From: Brian Banister [REDACTED]
Sent: 02 June 2022 09:46
To: Planning.Responses <Planning.Responses@arun.gov.uk>
Subject: Re: Planning Consultation on: LU/145/22/PL

Thankyou for the consultation. The comments of the **Arun District Conservation Area Advisory Panel** are as follows:

Application No: LU/145/22/PL

Description of Works: Two storey side extension and detached two storey building to north of existing house to create 4 No 3-bed dwellings. This application affects the character and appearance of the Littlehampton Seafront Conservation Area and is in CIL Zone 4 (Zero Rated) as flats.

TITLE
Proposed Plans

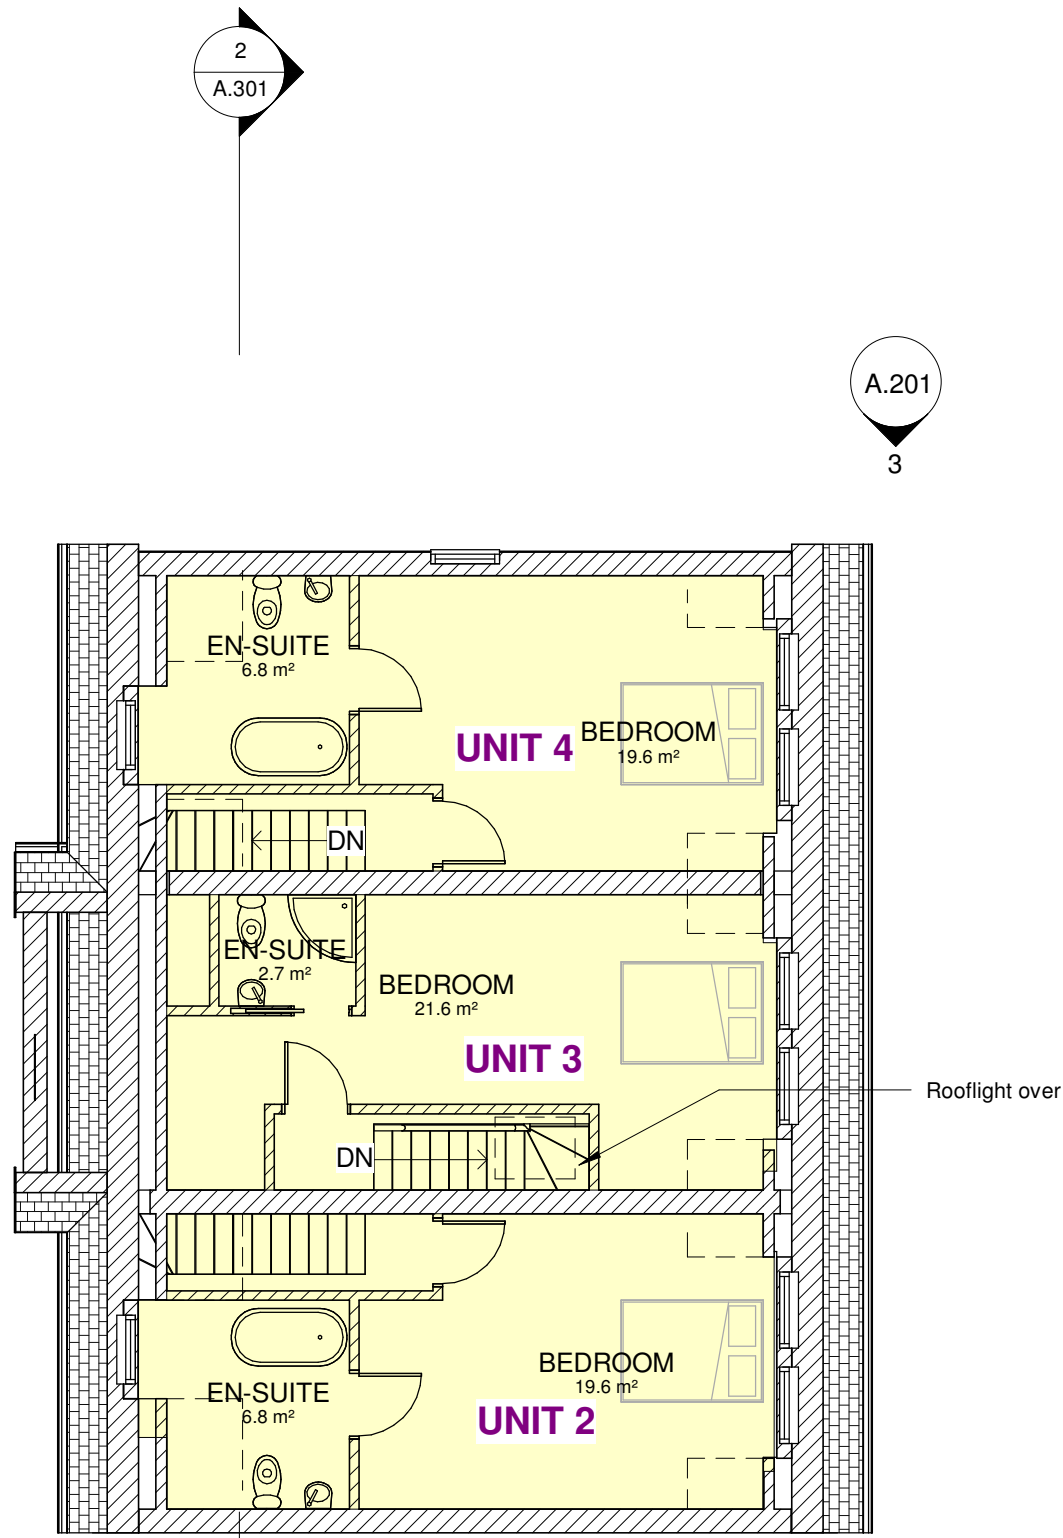
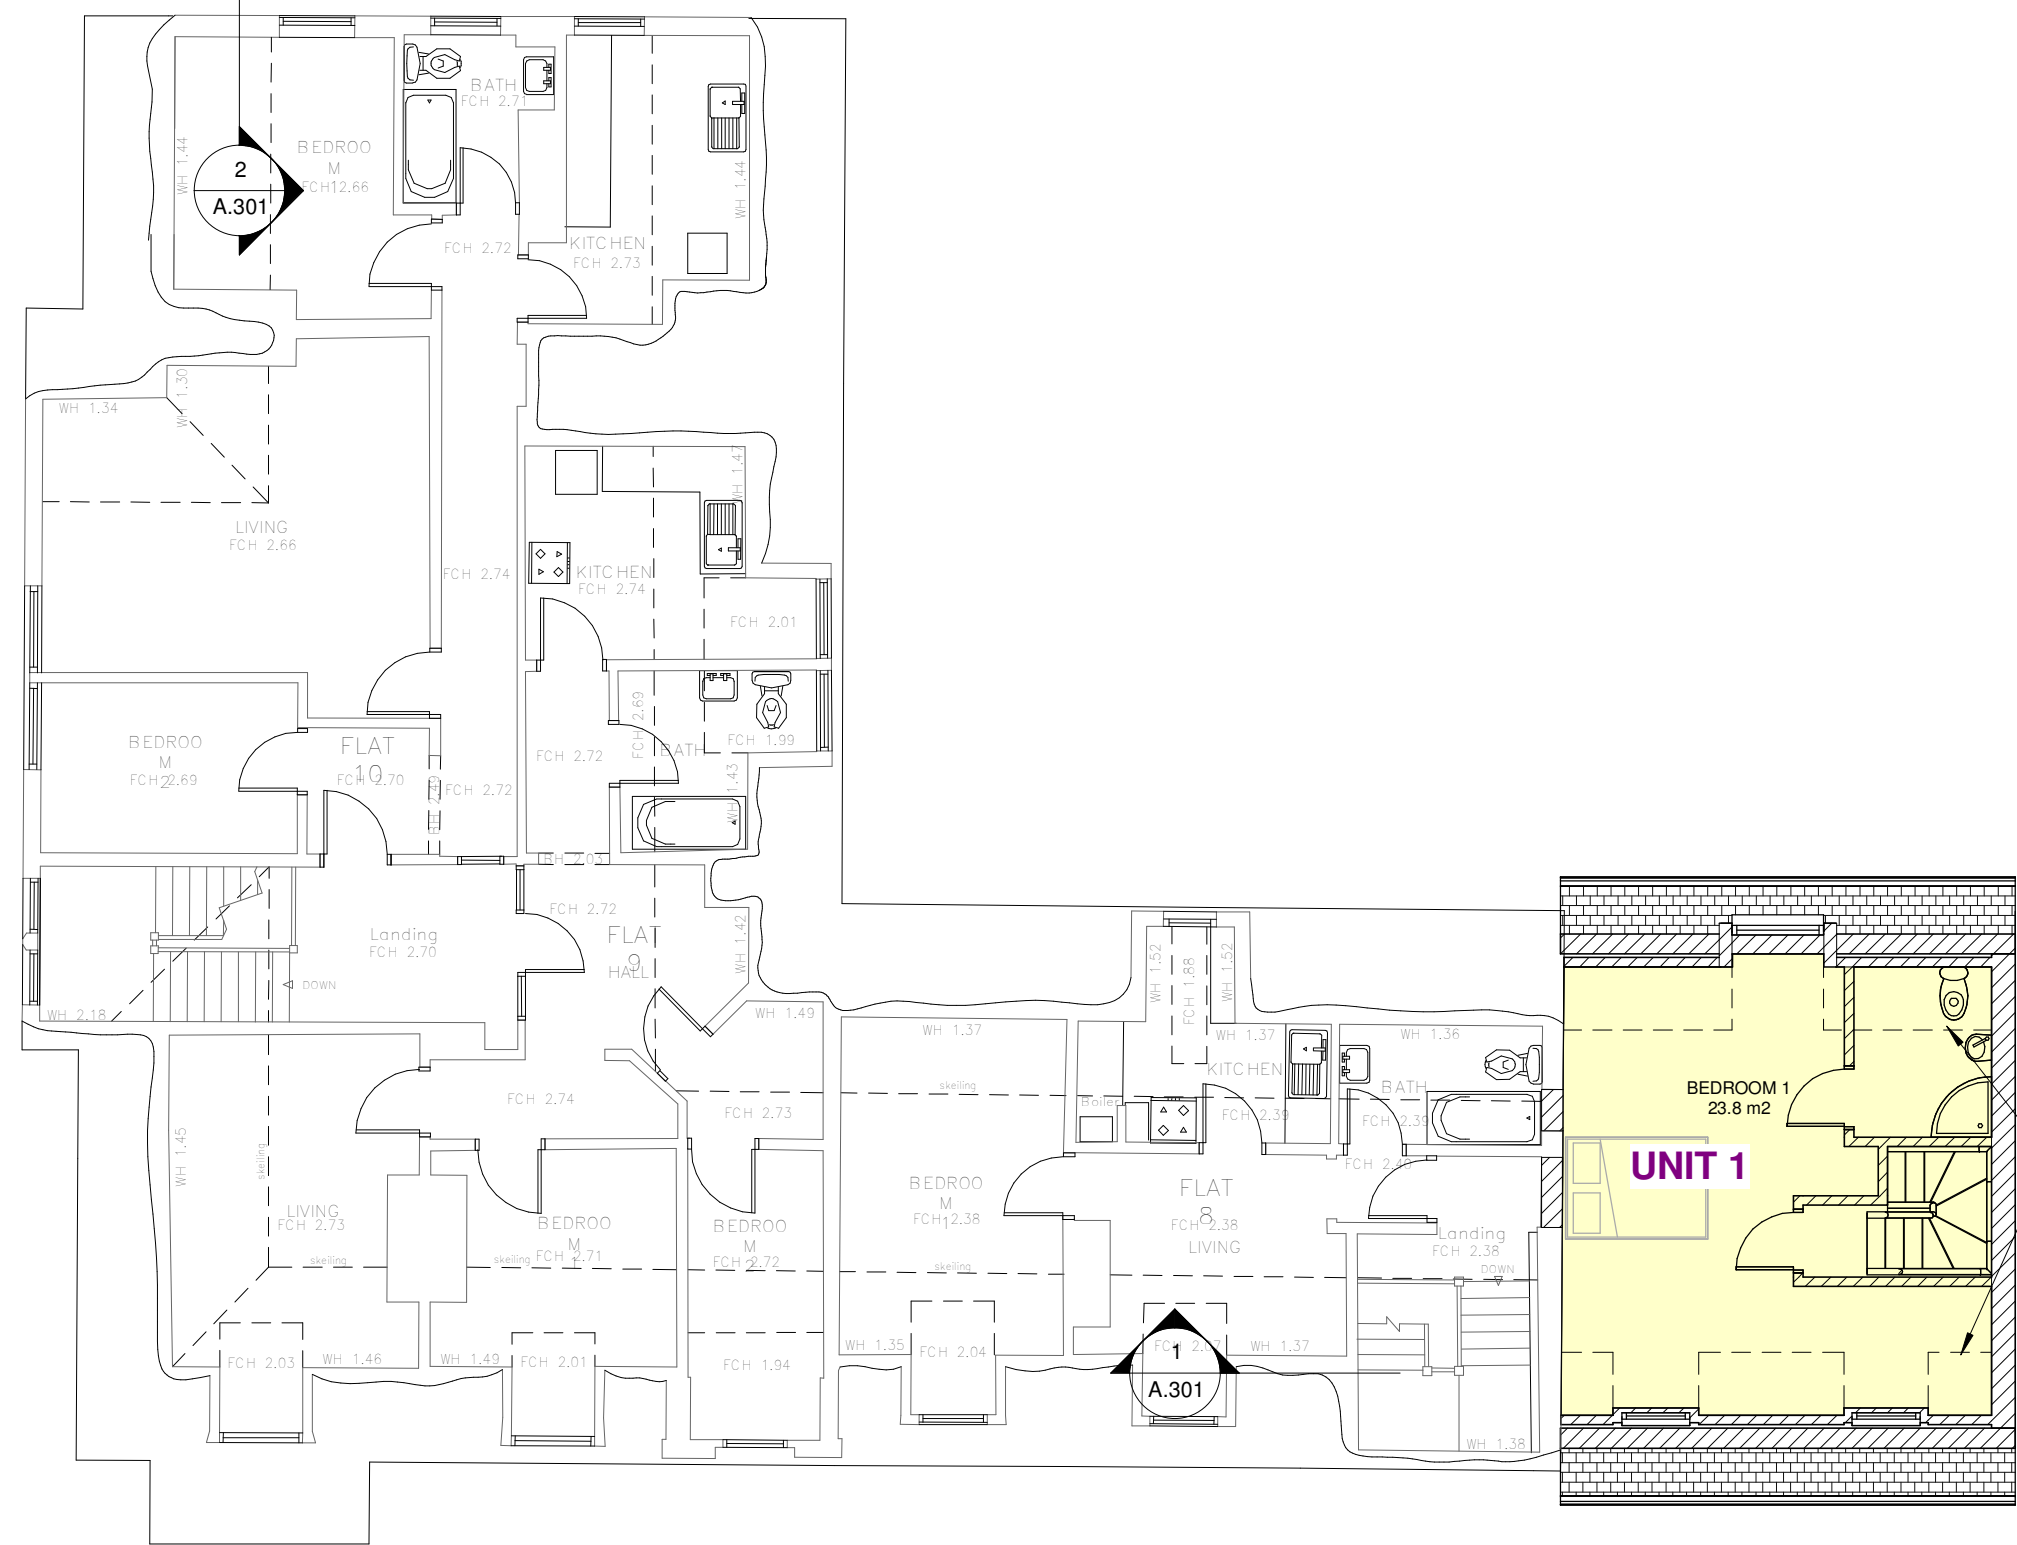
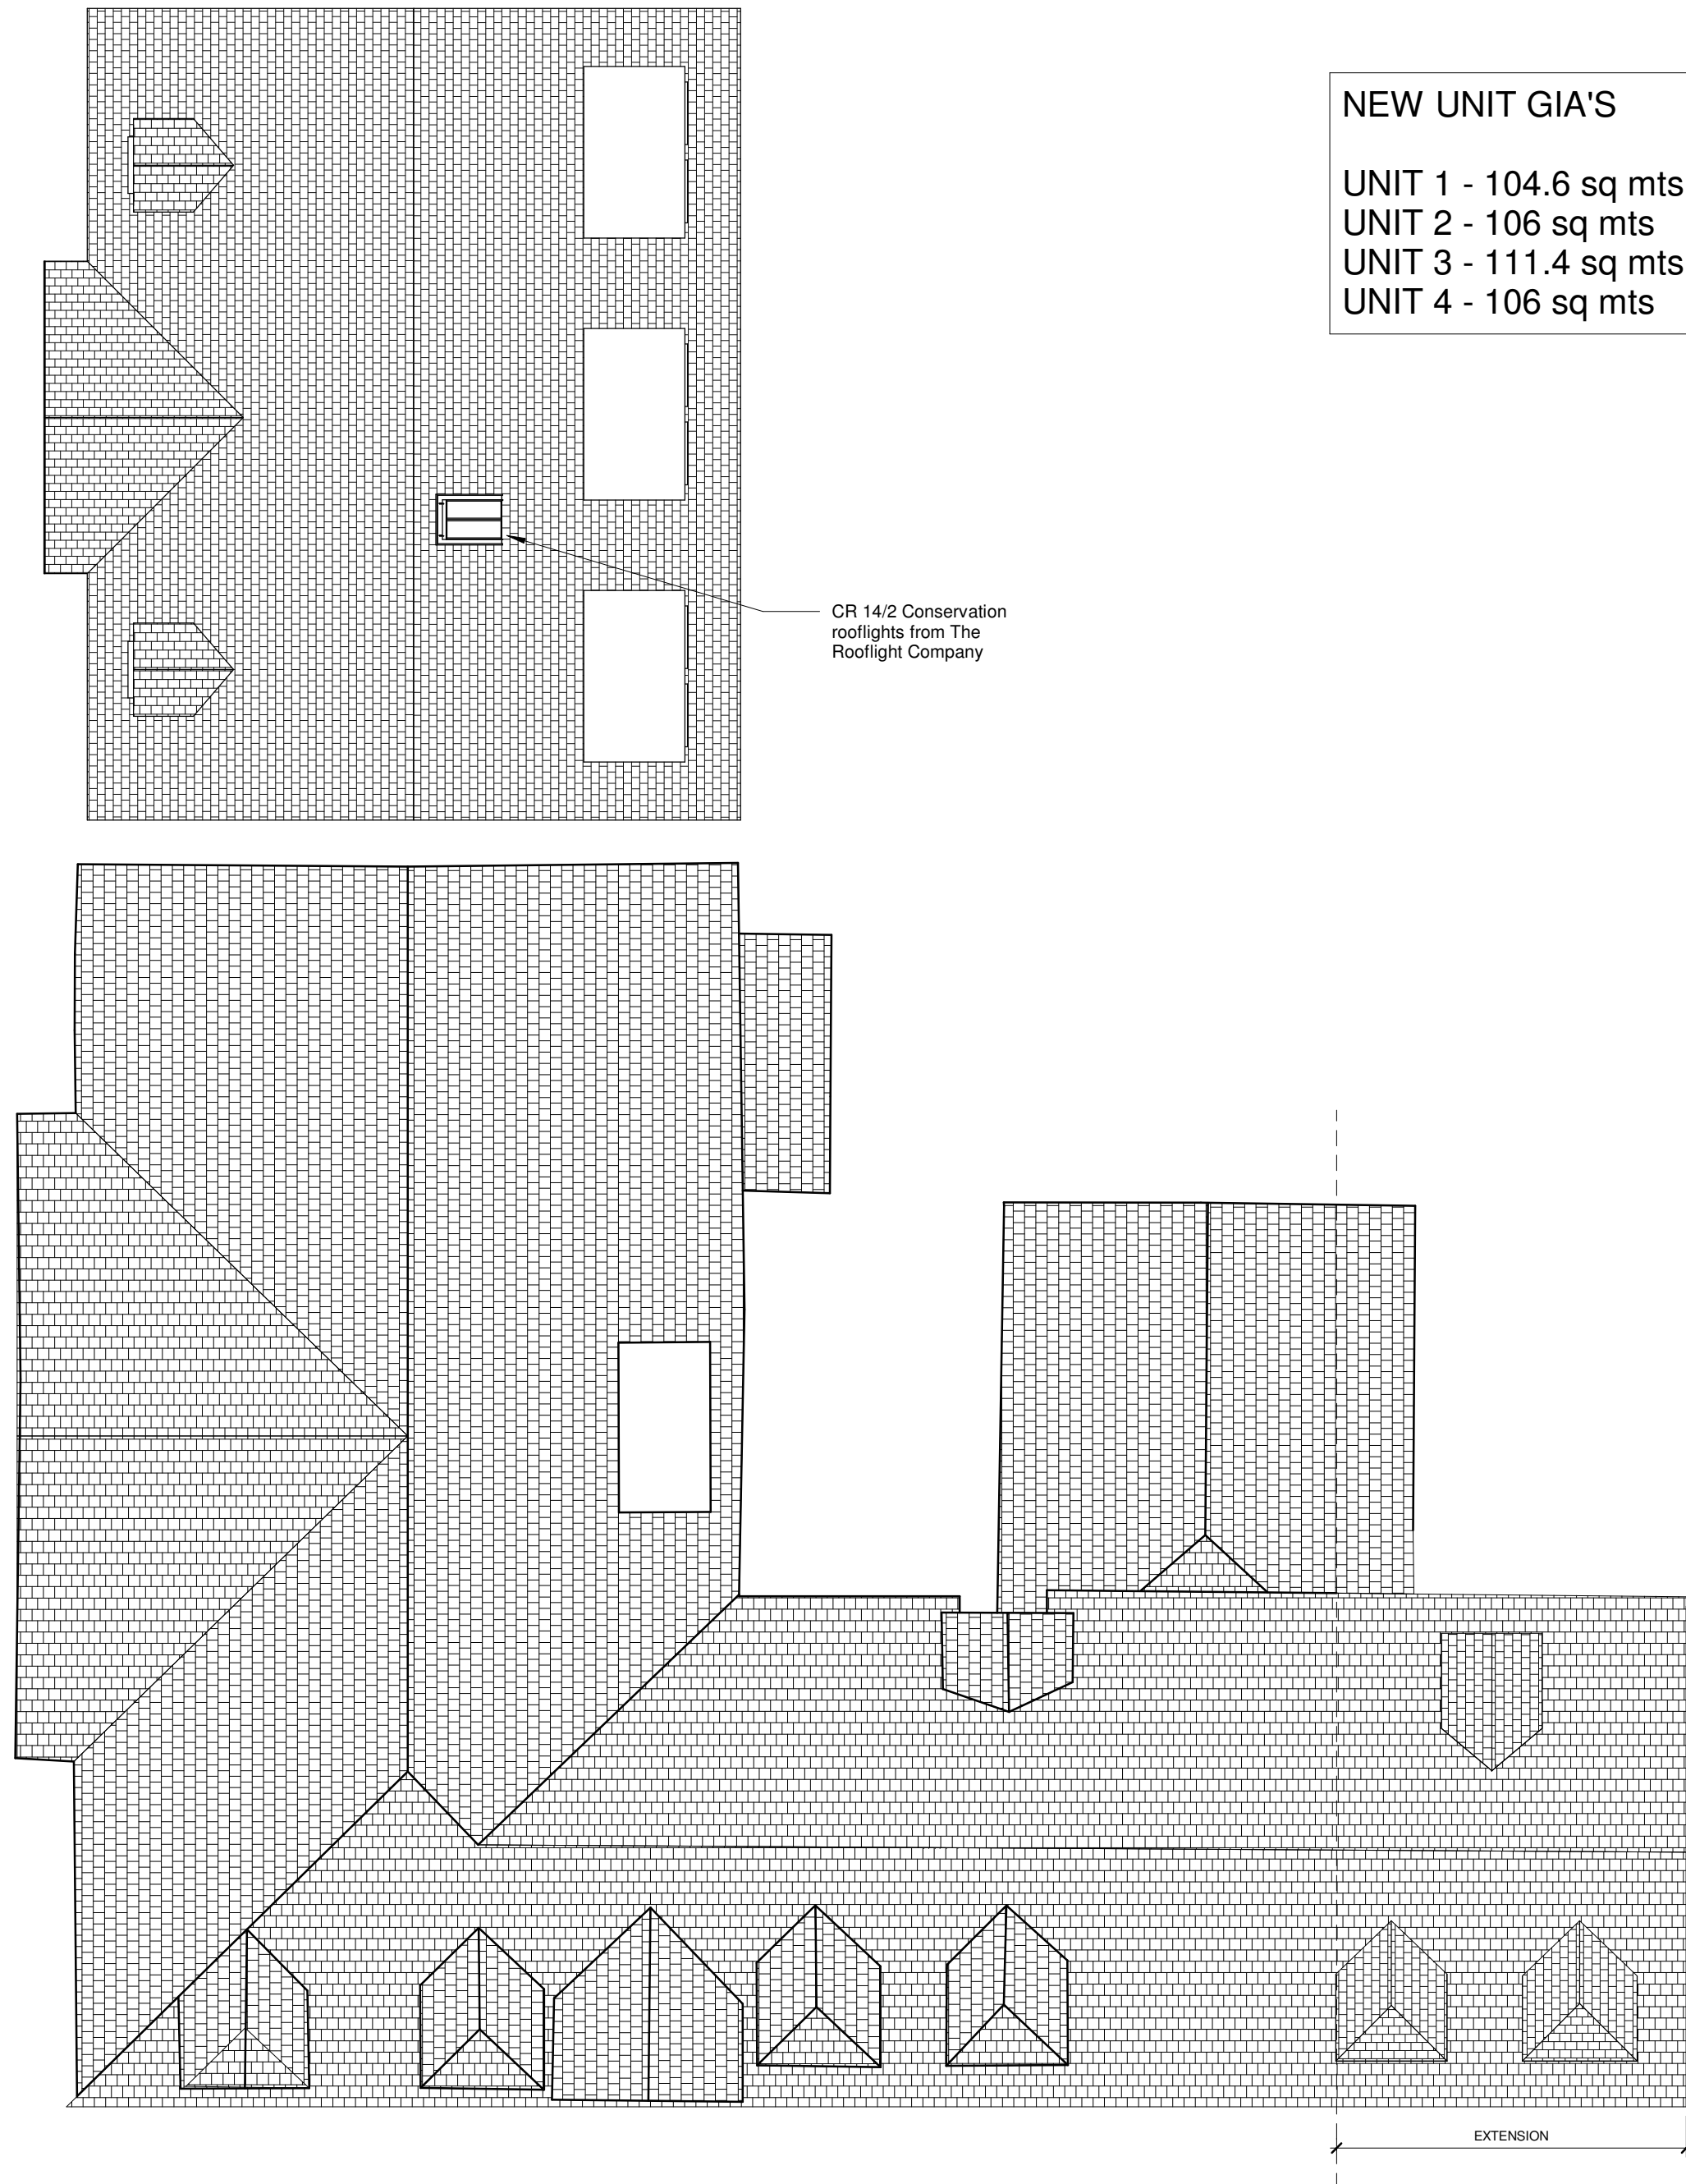
The elevational treatment also appears satisfactory but the Panel are concerned at any further proliferation of inappropriate concrete tiles and consider that plain clay tiles need to be used on the roof of the new terrace and that this should be established before any planning permission is granted. Their use on the proposed extension is problematical because the new and existing roofs are currently shown on the plans as being in the same plane. A setback could be used in wall and roof as a break in plane between the walls of the main building and the extension, allowing plain clay tiles to be used on the extension; a useful start to the eventual replacement of the inappropriate concrete tiles on the host building with what would then be matching plain clay tiles.

The quality and appropriateness of any new fenestration will also be important and the use of painted timber vertically sliding (not top hung) sash windows should be secured and which would also set an exemplar for any future replacement windows in the main building. Slimline double glazing could be appropriate in this instance. The general spaciousness of this part of the conservation area is an intrinsic feature of its suburban character which contrasts with the more urban and tight knit character of the eastern part. There is the loss of some space about the existing building but as mentioned above, in the Panel's opinion, the form, scale and disposition of the new buildings will be such that there will be no undue adverse impact on the character of the conservation area.
